RE: SSD 7603; Nos. 24-28 John Street and Nos. 4, 6, 8, 10, 12, 14, 16, 18, 20, 22, 24, 26 and 28 Board Street, Nos. 3, 5, 7, 11, 13, 15 and 17 Ann Street, Lidcombe 2141 NSW

I object to part of the abovementioned proposal, namely the above-ground multistorey carpark that will be constructed on Board and Ann Street. I have not included any objection to the proposed hotel in this submission. Internet hyperlinks have been included for your convenience.

Disabled Carpark Bay
14
Standard Carpark Bay
594
Grand total: 608

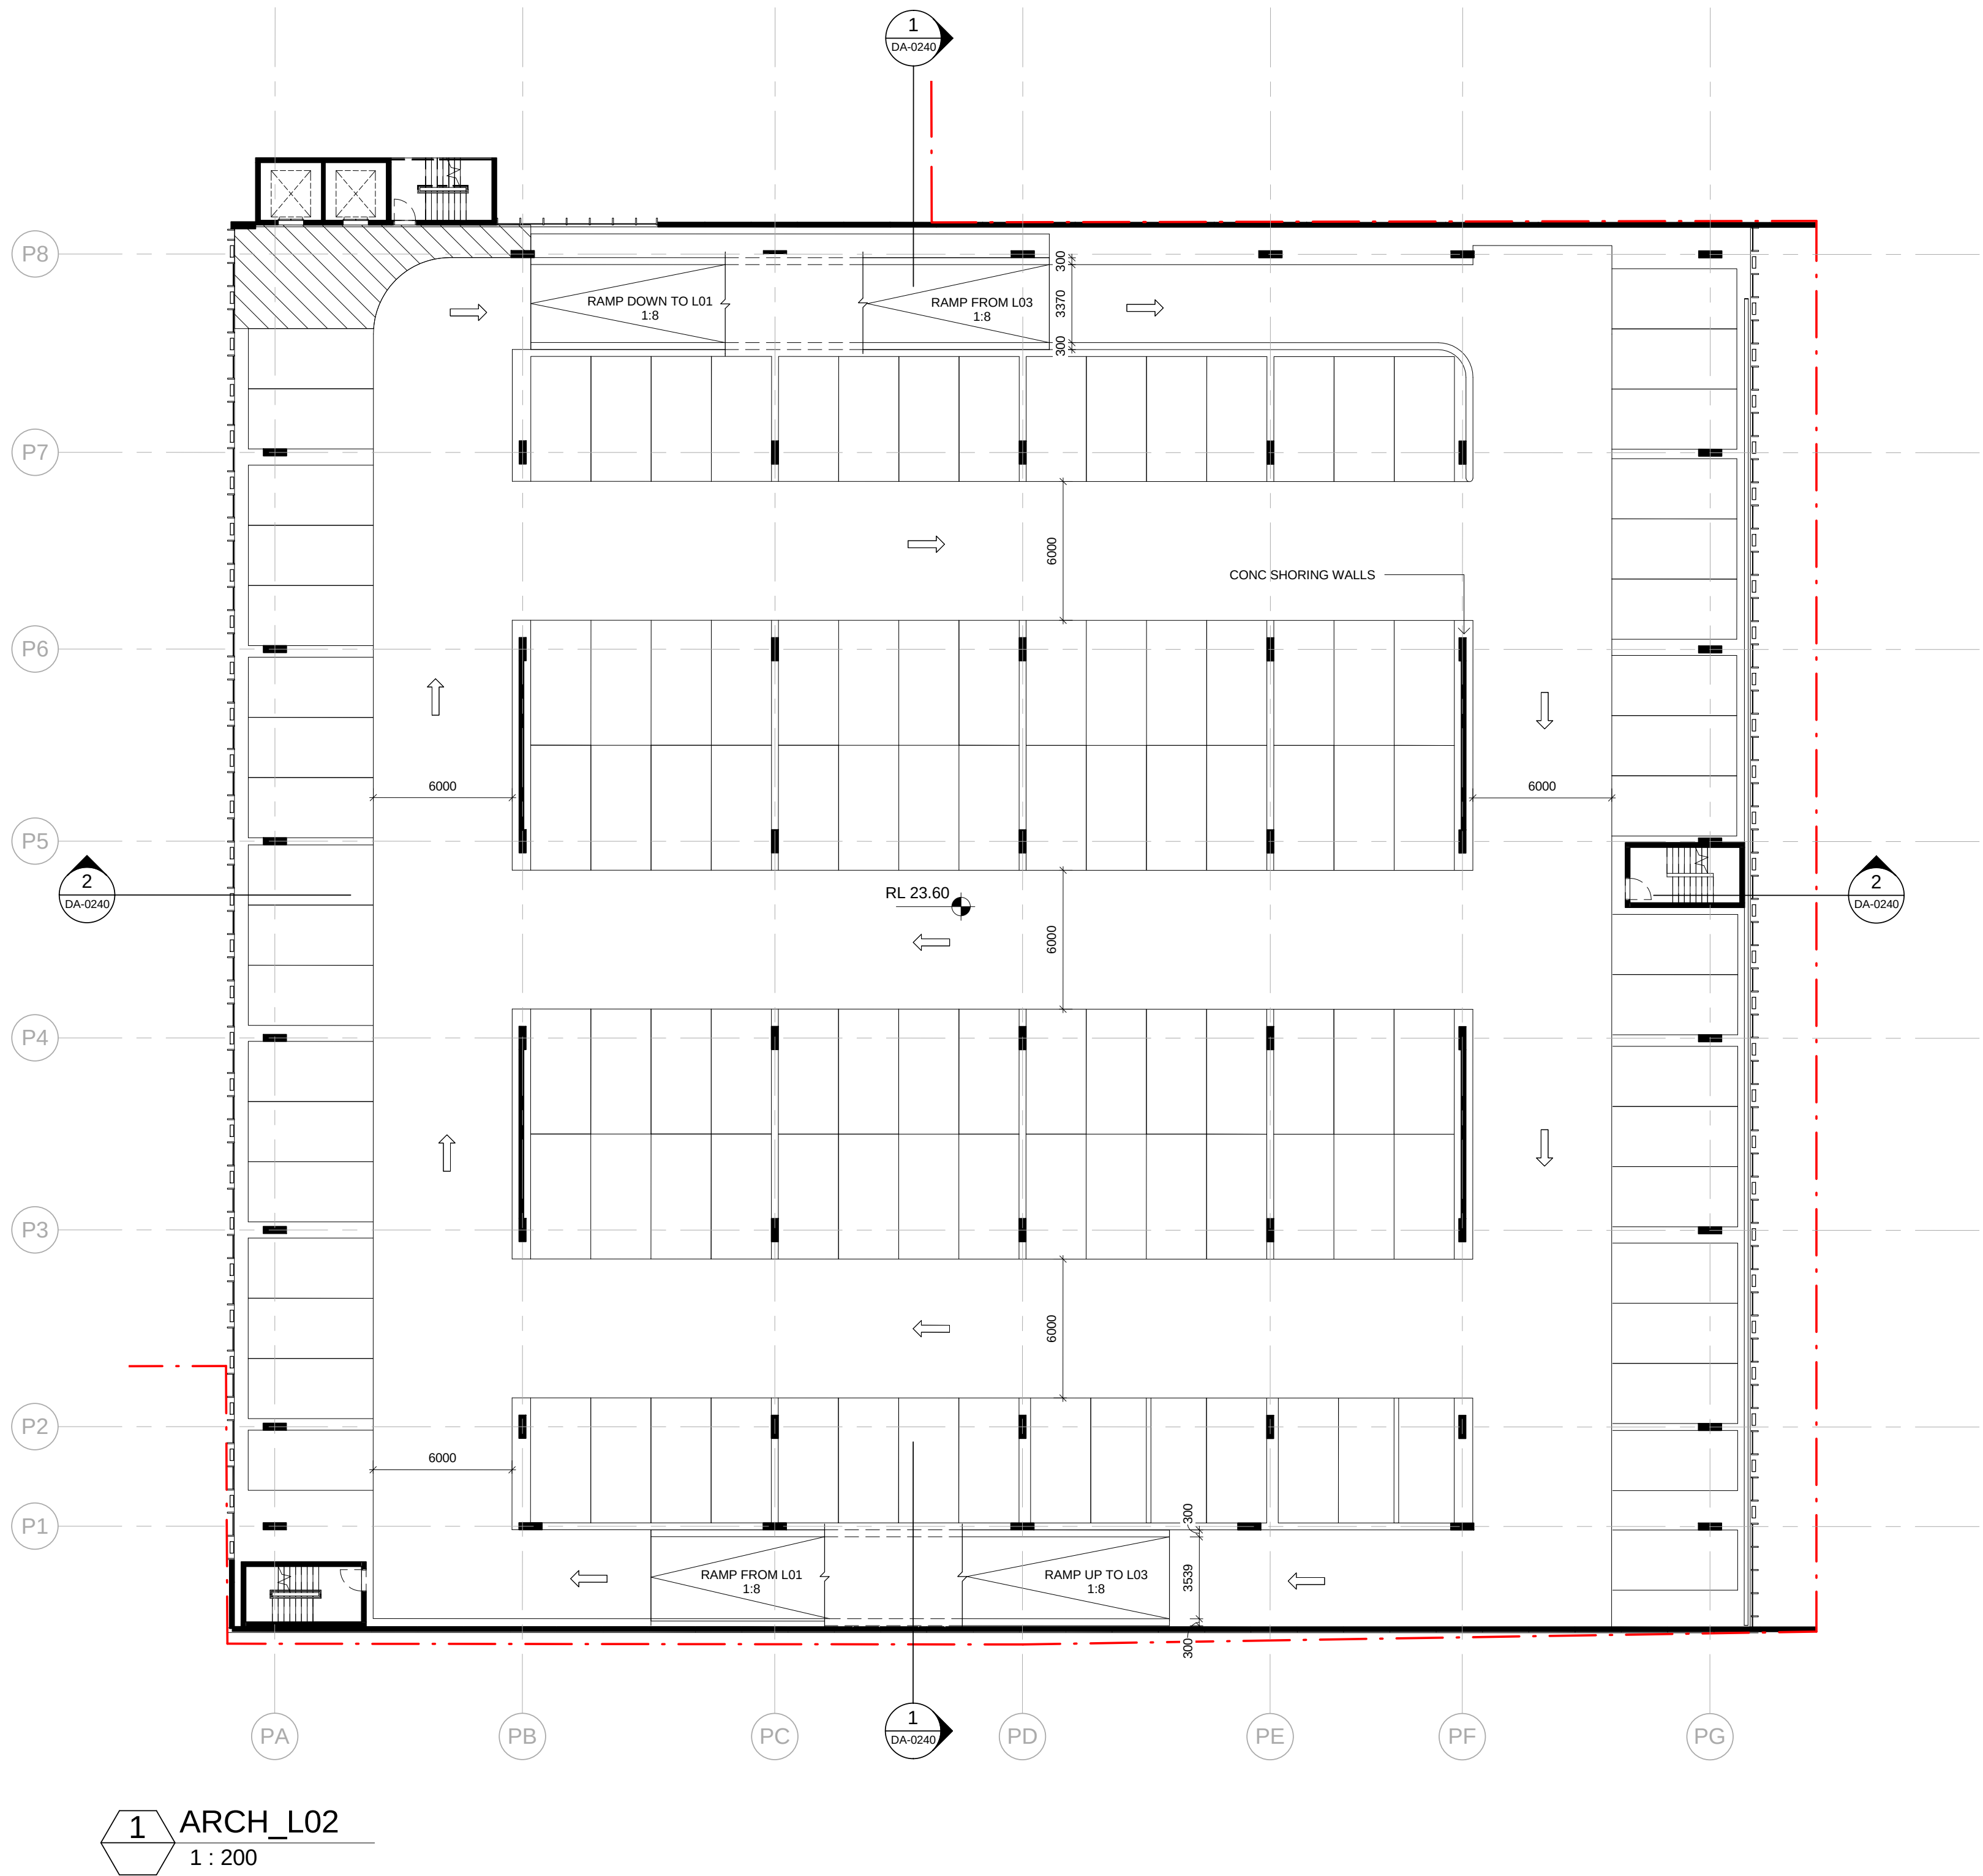
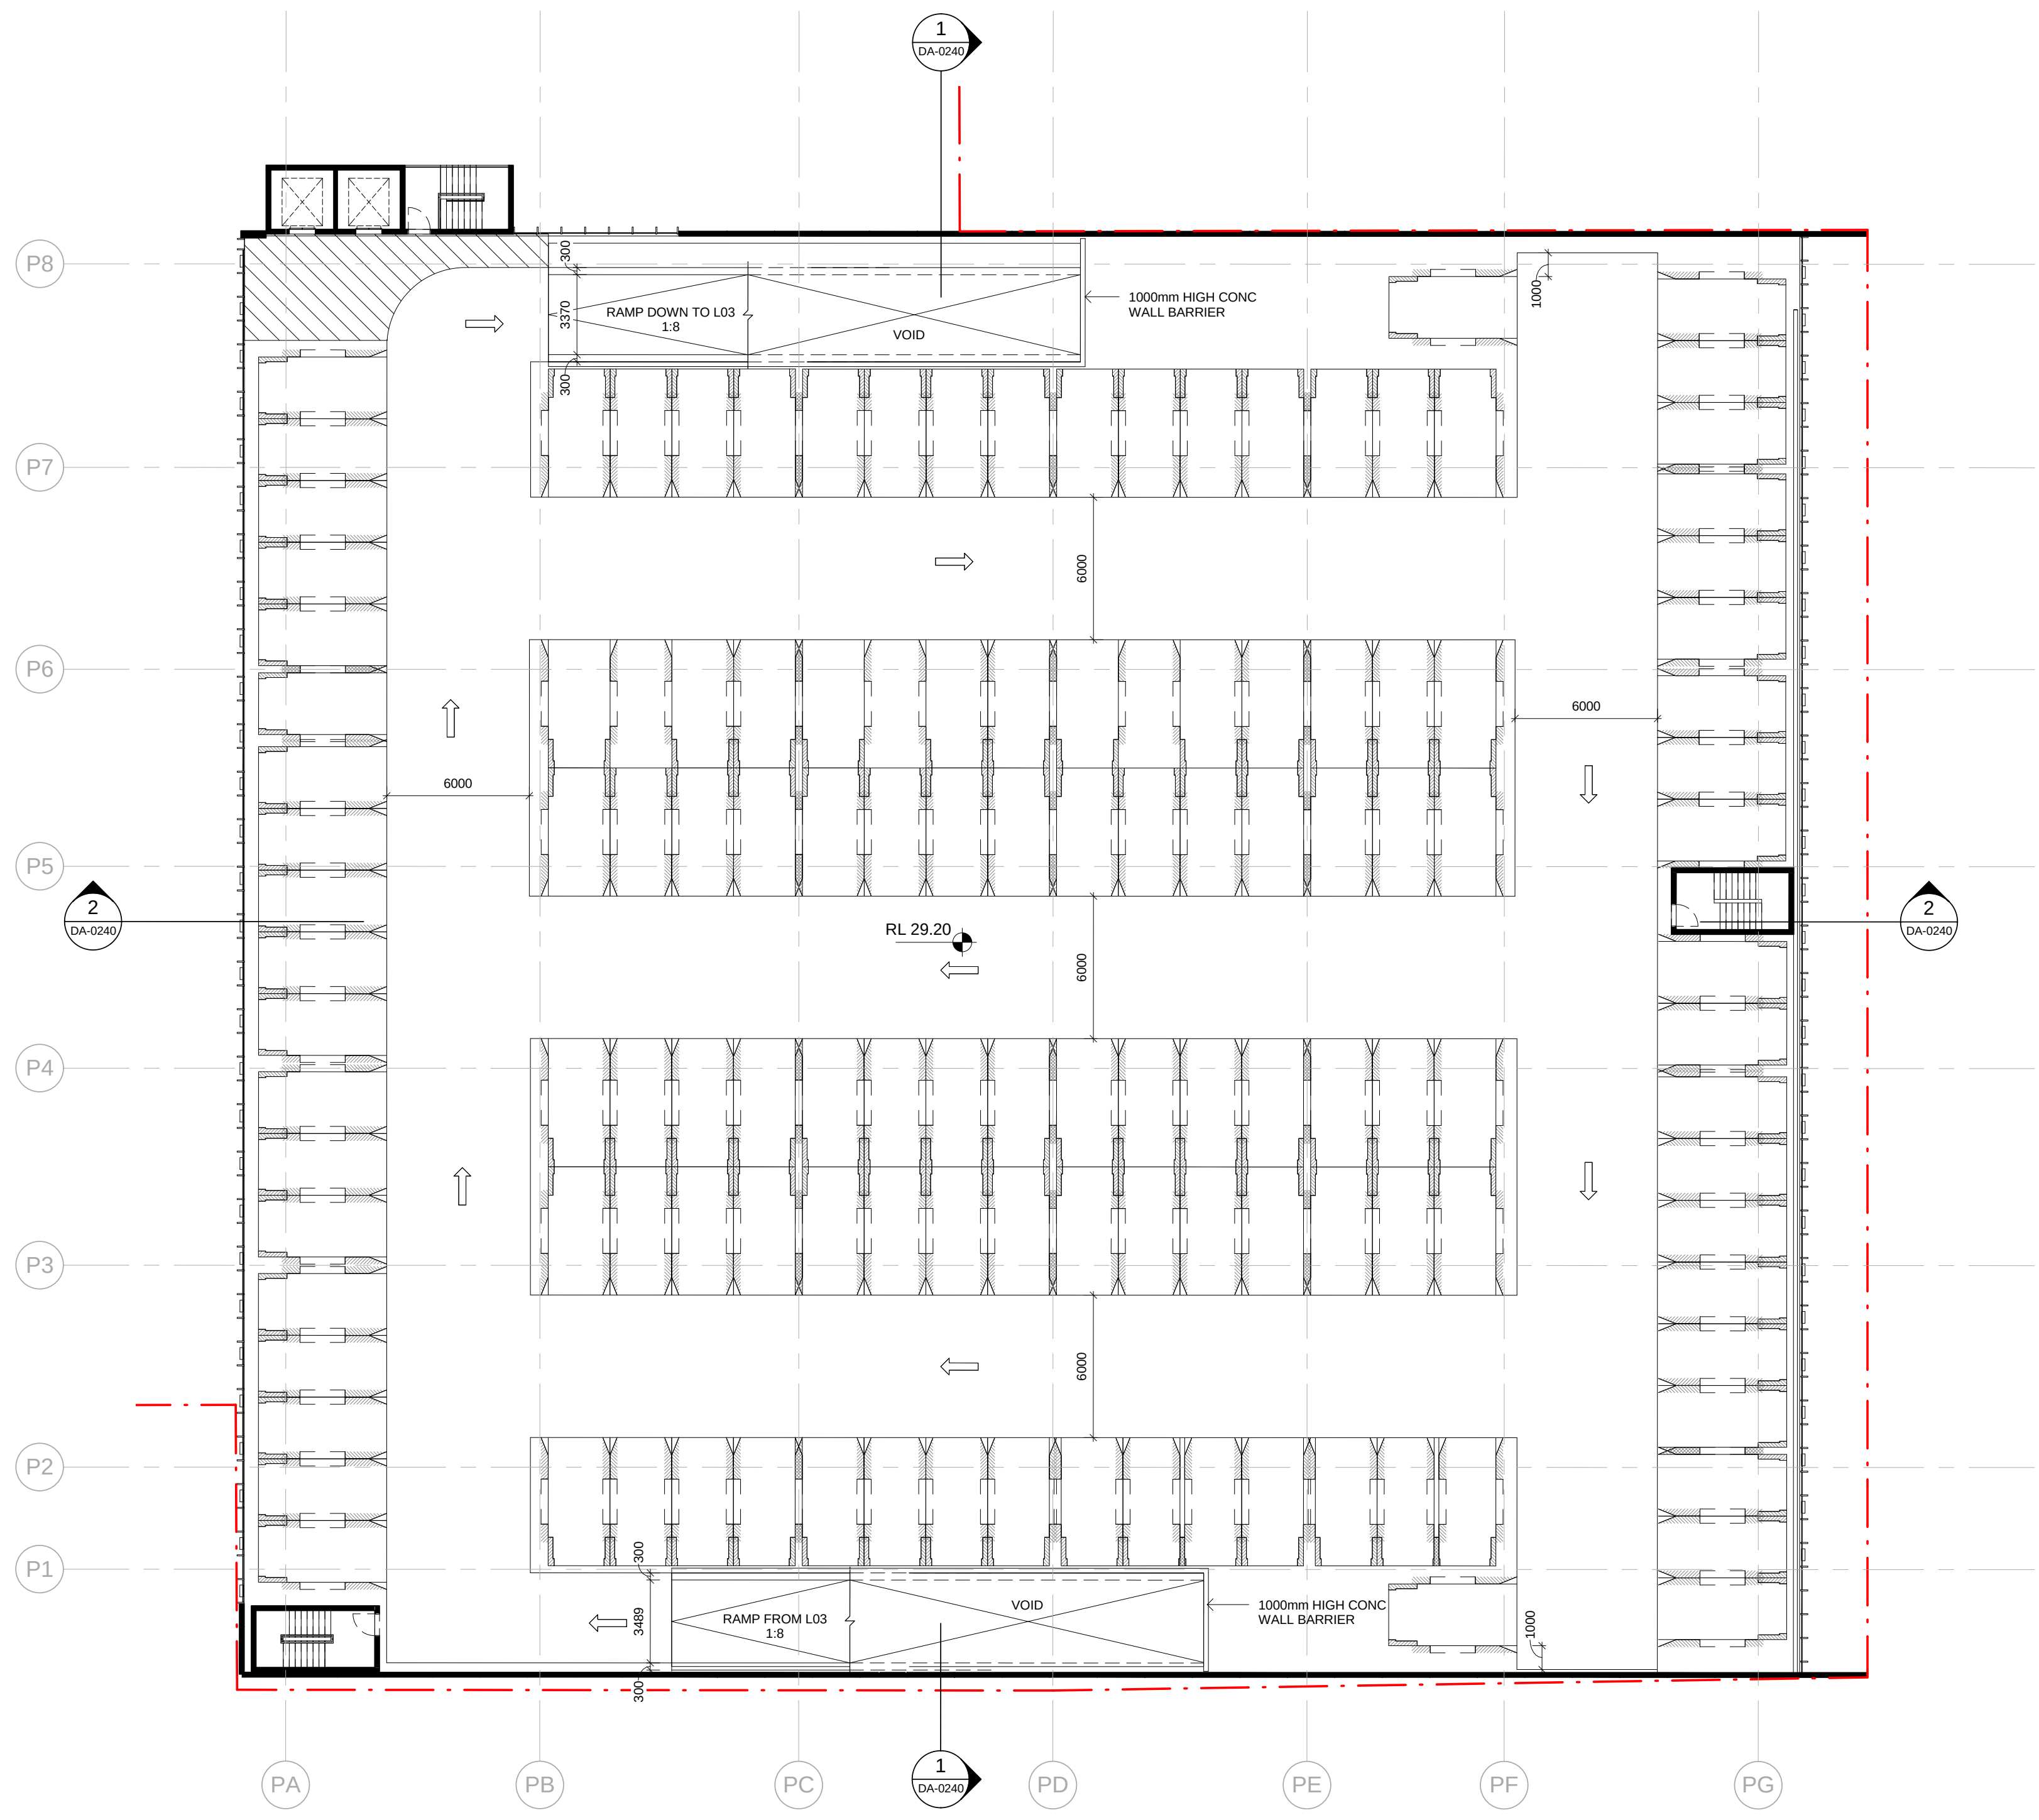
C 1 Overshadowing and reduced access to amenity - with the construction and operation of the proposed carpark on Board and Ann Street there will be dramatic overshadowing and reduction in solar access affecting my property. My property is already adjacent to the previously approved multistorey development at 36 – 44 John Street (currently under construction as of writing), which already has a significant overshadowing effect on my property. It is only logical to consider the cumulative impact of the proposed carpark (to the west) and the existing multistorey development (to the east) on my property.

The proposed carpark will decrease my solar access from current levels to a much smaller window of time. Currently, with the existing multistorey development on my eastern boundary, on the winter solstice (June 21), my property receives a little under five hours of uninterrupted access to sunlight in private open space between 9 – 3pm in good weather. With this proposed carpark, the loss of solar amenity would be exacerbated and solar access reduced to less than 3 hours. This will be further explained in **Appendix A**.

C 2 Residential Interface - the proposed carpark will be built much too close to my western boundary. My property would then be closely flanked on both my western and eastern boundaries by multistorey developments.

- I 1** Instead of building so close to the boundary, setback the proposed multilevel carpark **at least 3 metres** from our common boundary.
- I 2** Instead of the current design with no stepping down, change the design of the carpark such that there is a **step-down**, with the higher storeys being closer to Olympic Drive than those closer to my property. In Figure 1, I have shown a situation where I would increase my solar access. The eastern wall of the first storey could be spaced at least 10 – 12 metres from the eastern wall of the second storey. The eastern wall of the second storey could be spaced at least 10 – 12 metres from the eastern wall of the remainder of the storeys.
